The Examining Authority's questions from Issue Specific Hearing 4

Issued February 2020

Derby City Council – Answers to Questions

FIGURE 5.2B  
STUDY AREA FOR CONSTRUCTION  
PHASE TRAFFIC IMPACTS

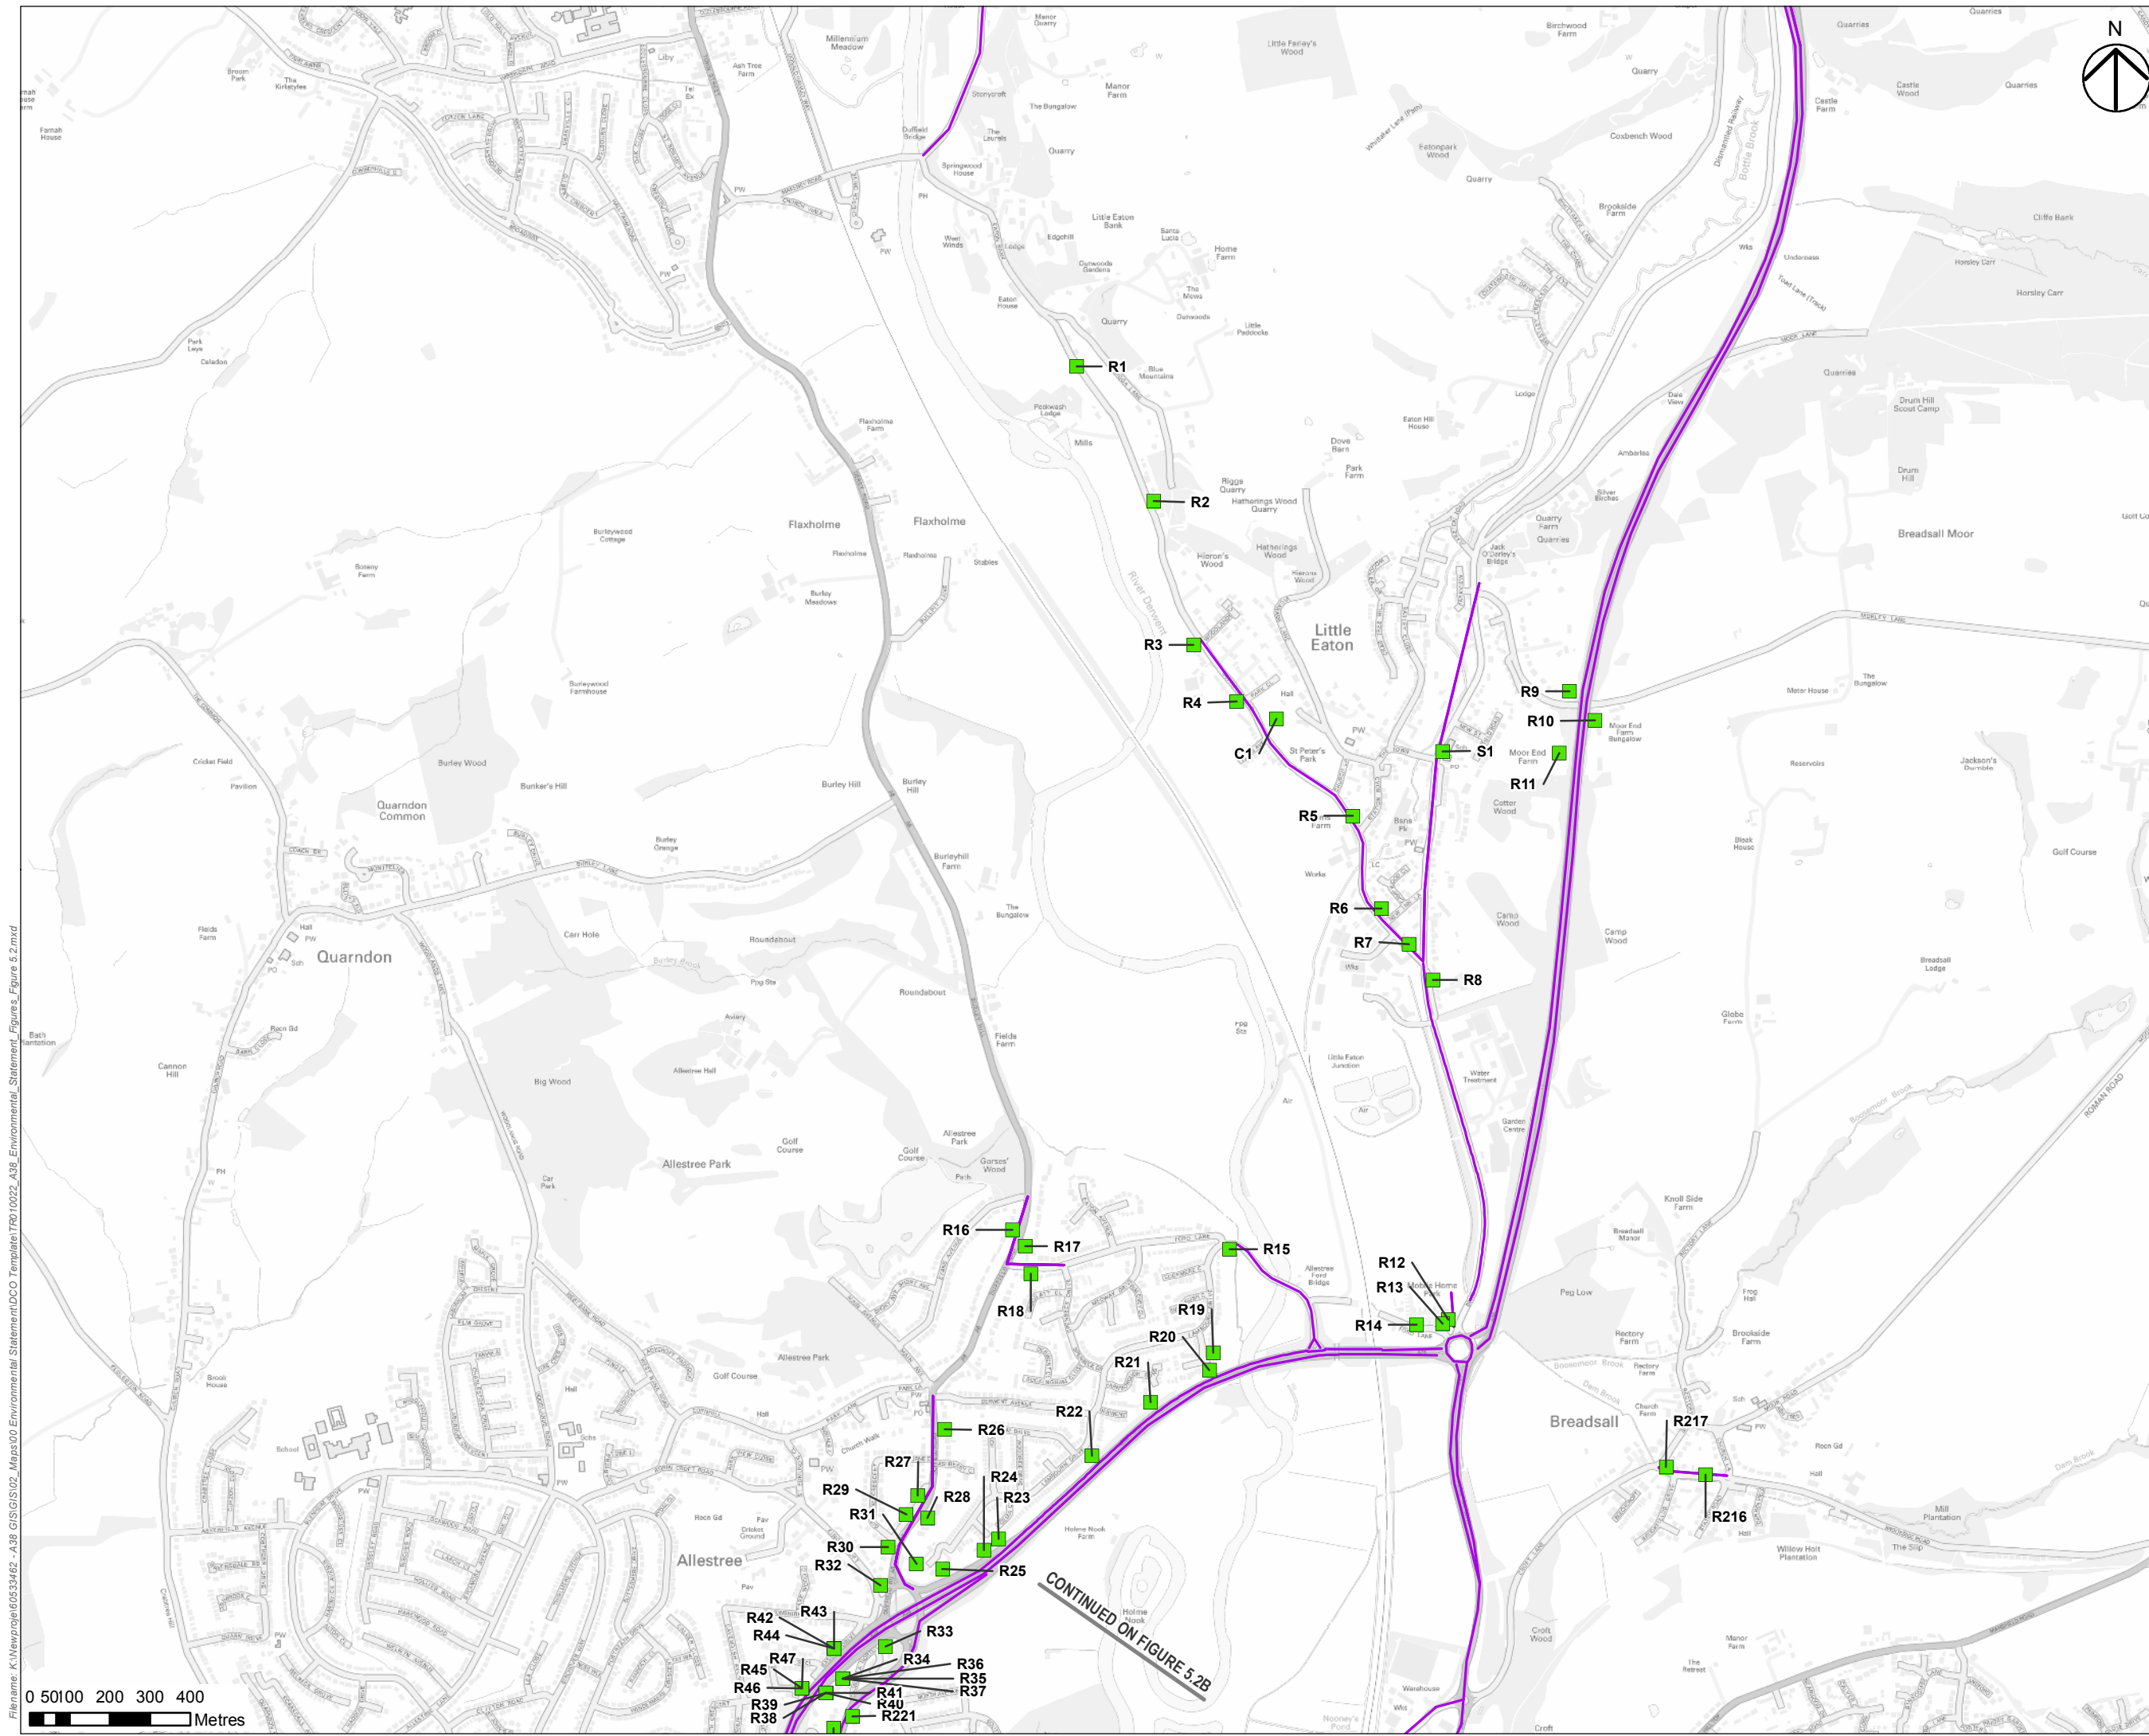
<p>changes to congestion, route uncertainty, journey reliability and journey times on the local road network during construction. Consideration given to the inner ring road and major routes identified by DCiC.</p>	<p>management schemes if they don't operate as predicted.</p> <p>As such, it is how the applicant approaches the wider traffic management of such impacts during construction, and their commitment to maintaining the efficient movement of traffic (within reason) that is important.</p>
3 c)	<p>The modelling of queuing and junctions, the adequacy of the Saturn model and the need for LINSIG modelling for the assessment of impacts arising from disruptions to the local road network during construction.</p>	<p>The DCO places an obligation on the applicant to define their traffic management strategy through the Traffic Management Plan (TMP), and a process of governance. This is clear and DCiC does not have any issue with this or the wording in the DCO. However, it has been the content of the TMP and uncertainty over the exact construction phasing, until the detailed design is complete, which raised questions for DCiC.</p> <p>There have been further discussions with the applicant, and their contractor LinkConnex, and the TMP has been redrafted to provide more definition on communication, design and management processes. The inclusion of junction modelling to inform the design of temporary junctions as part of the traffic management phasing is an important step. Further, a commitment through the TMP to engage with transport operators and user groups, major businesses and public service providers through the Behaviour Change Group is also positive. LinkConnex and Highways England has actively engaged with this group and begun to discuss a communication strategy and liaison over traffic management.</p>

**FIGURE 2.12A
ENVIRONMENTAL
MASTERPLAN
(KINGSWAY JUNCTION)**

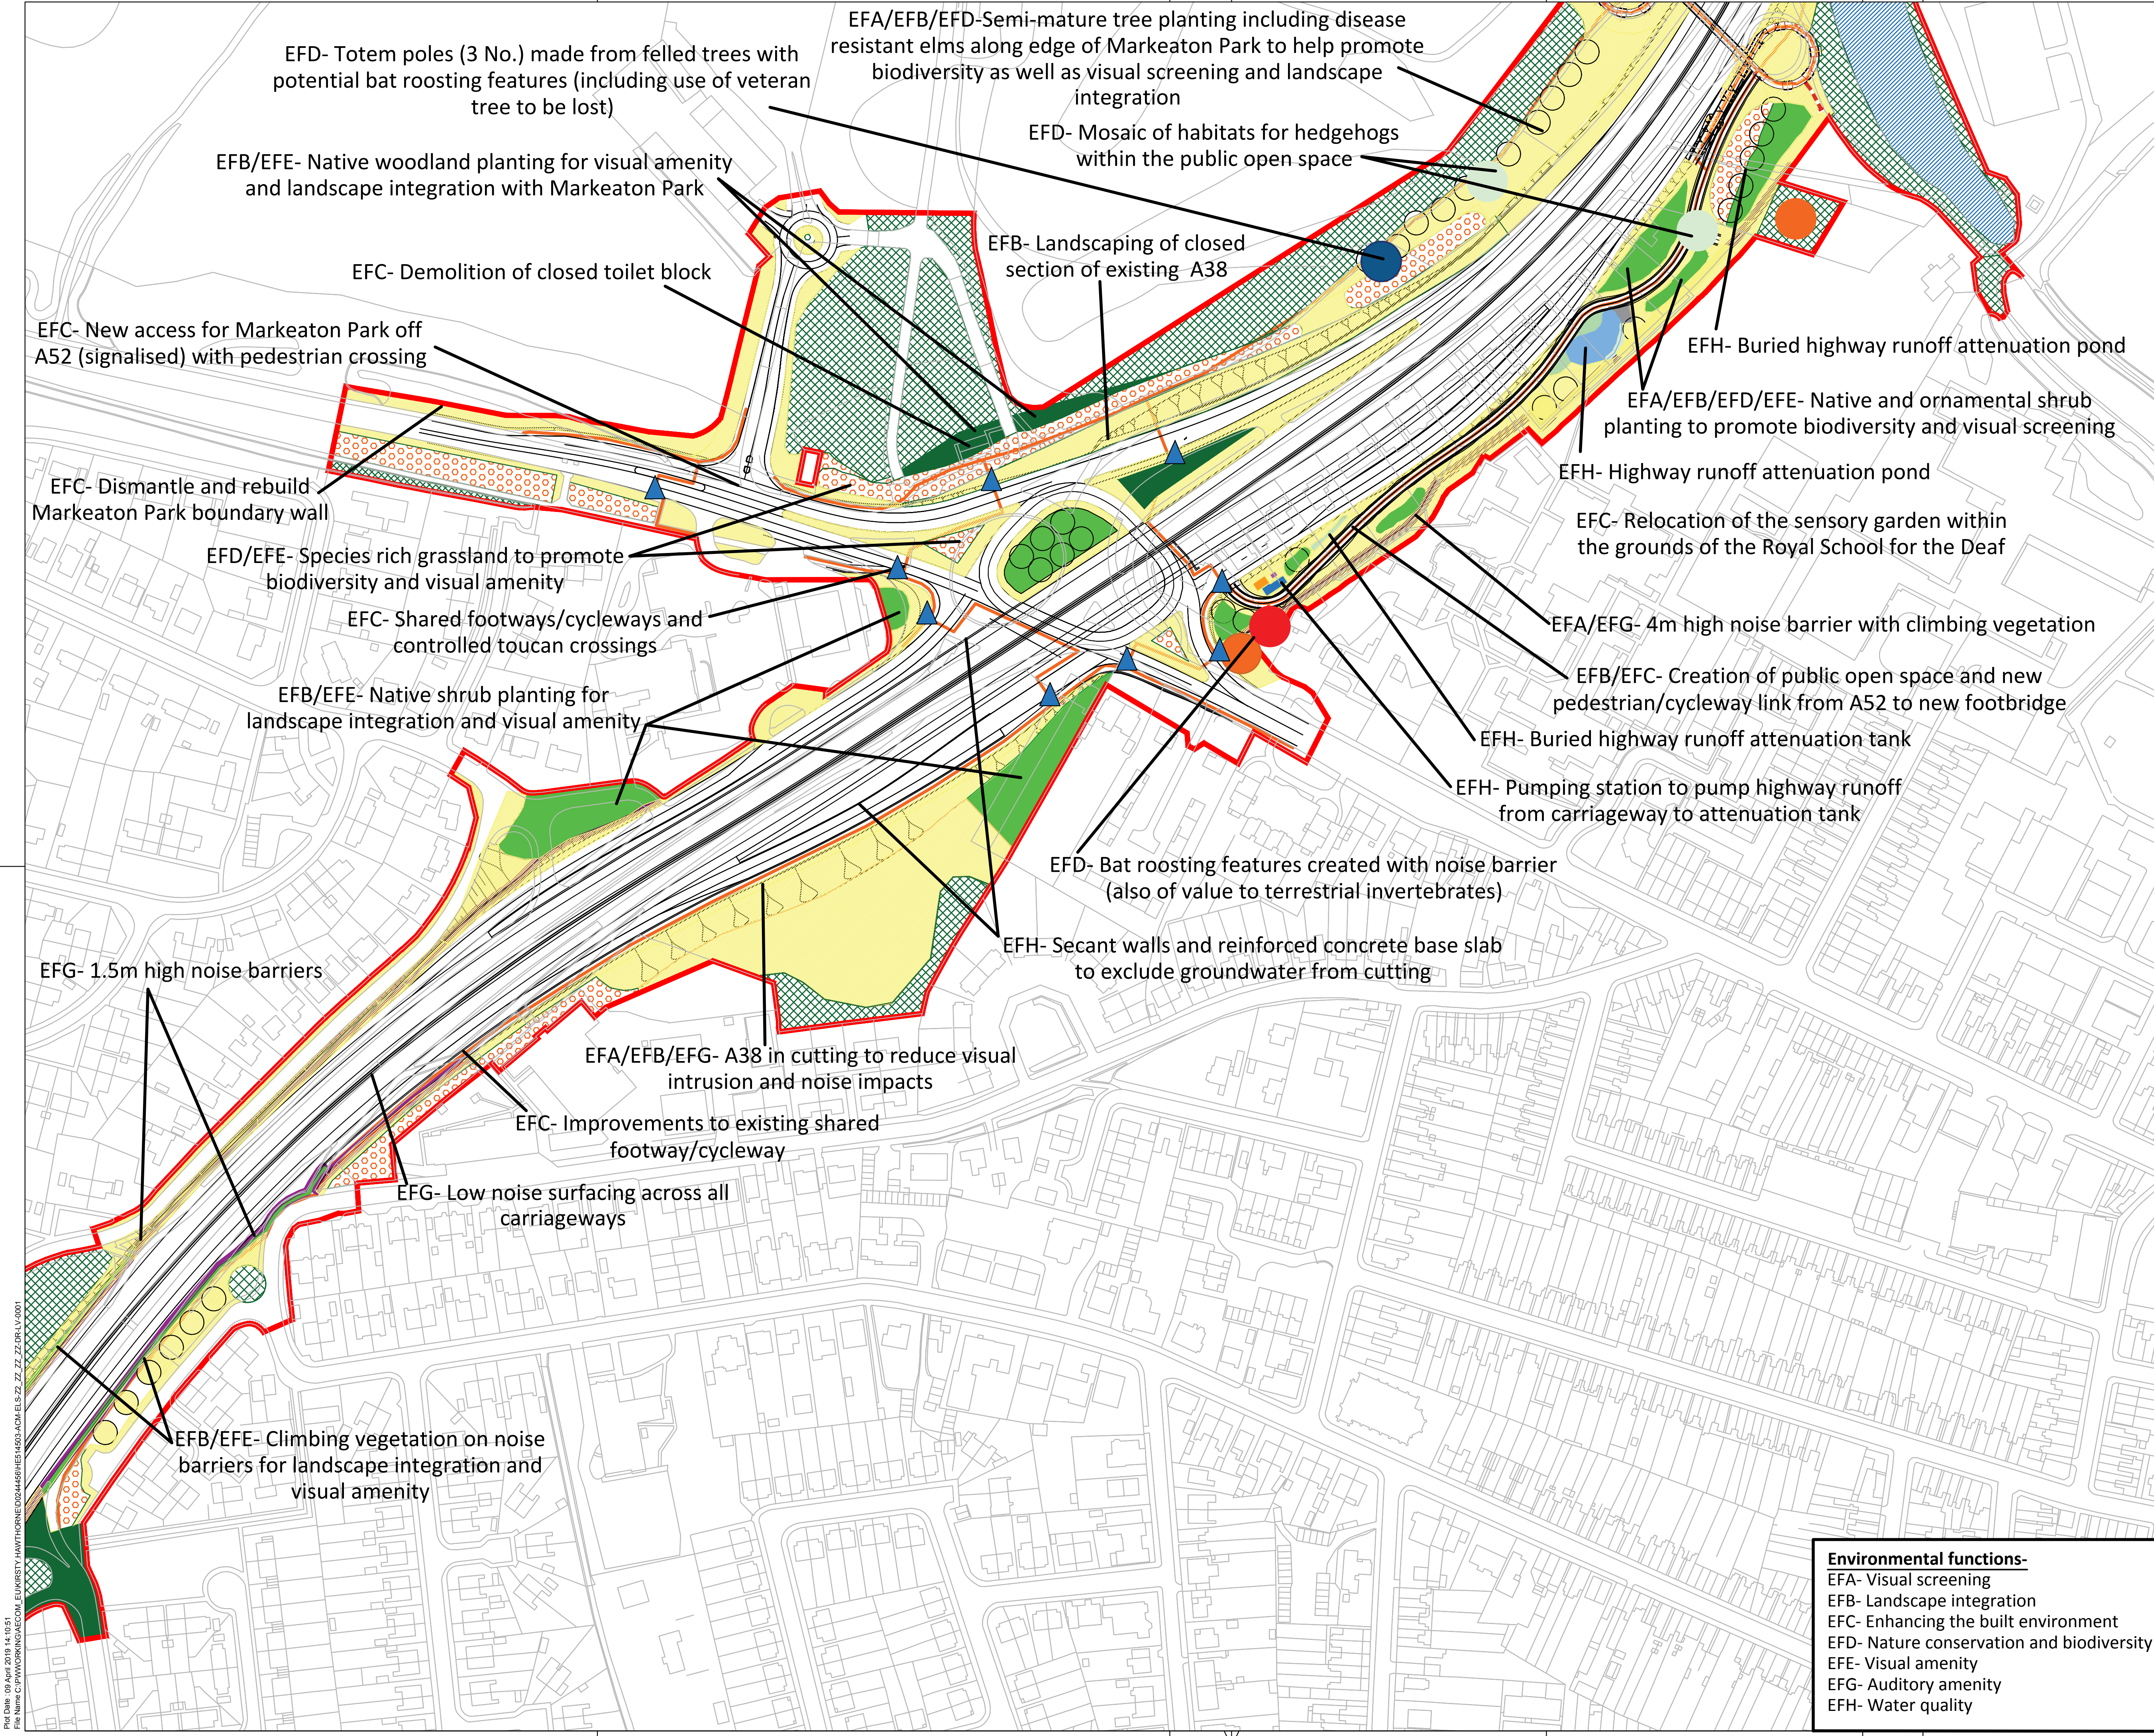
<ul style="list-style-type: none">• 24 Hour AADT link flows;• Road Safety;• Walking and cycling• Public Transport <p>The assessments provide a broad measure of the impacts of the A38 Scheme on a range of assets and road users. There is no doubt that overall the A38 scheme will provide journey time, road safety and air quality benefits to both the trunk road and local road networks. However, DCiC has highlighted in previous answers to hearing questions that there might be particular junctions where there are significant changes to movements in traffic that will alter how they operate and potentially reduce their capacity. Broad metrics such as Driver Stress or changes in journey time do not provide an assessment of the changes in operation of junctions and impacts of queuing. The concern for DCiC is that as a minimum some junction signal timing might need adjusting to cope with changes to turning movements, however, changes to geometry might be required.</p> <p>To put this into context it is the same process of assessment that the A6/Ford Lane Junction has been through. It was identified that there was a significant change in turning movement at this junction and therefore it was tested using a more detailed junction model.</p> <p>DCiC provided the following examples in answer questions raised at Hearing 2.</p> <ul style="list-style-type: none">• Manor Road/Uttoxeter Road. Manor Road shows an increase of around 300 pcus in AM1.• Kingsway Junction/Cherry Tree Close/ Kingsway Retail Park.

<p>+265 increase towards Retail Park from A38 in AM2 Peak.</p> <ul style="list-style-type: none"> • Uttoxeter New Road/Brick Street/ Ashbourne Road. A61 Sir Frank Whittle Way/ Alfreton Road. +224 increase from junction towards A38 in AM2 Peak, +163 increase towards A38, mixture of increase/decrease on other arms. • A608/A61/ Hampshire Road. No significant change, this could be to do with the routing through the Meteor from Mansfield Road – increase through meteor is 253 in AM2 peak. Decrease on north and south bound towards Pentagon. • Kedleston Road Slips. AM2 +150 right turn and 242 left increase to southbound on-slip A38. • A38(T)/ A6 Duffield Road – Palm Court Island. +397 increase in northbound off slip in AM2 peak – increase of 332 on A6 Duffield Road approach from the north. <p>At a meeting held on 27/02/2020, Highways England reaffirmed it's position that the A38 Scheme will provide wider benefits across Derby's highway network. Further, the funding for the A38 Derby Junctions Scheme does not include funding for wider mitigation. However, Highways England suggested that a mechanism of monitoring the operation of the wider network is include in the OEMP. If significant operational impacts were identified as part of this process then the results could be used to petition for funding, either through Highways England or other funding routes. DCiC wants to see a commitment to such a mechanism.</p>
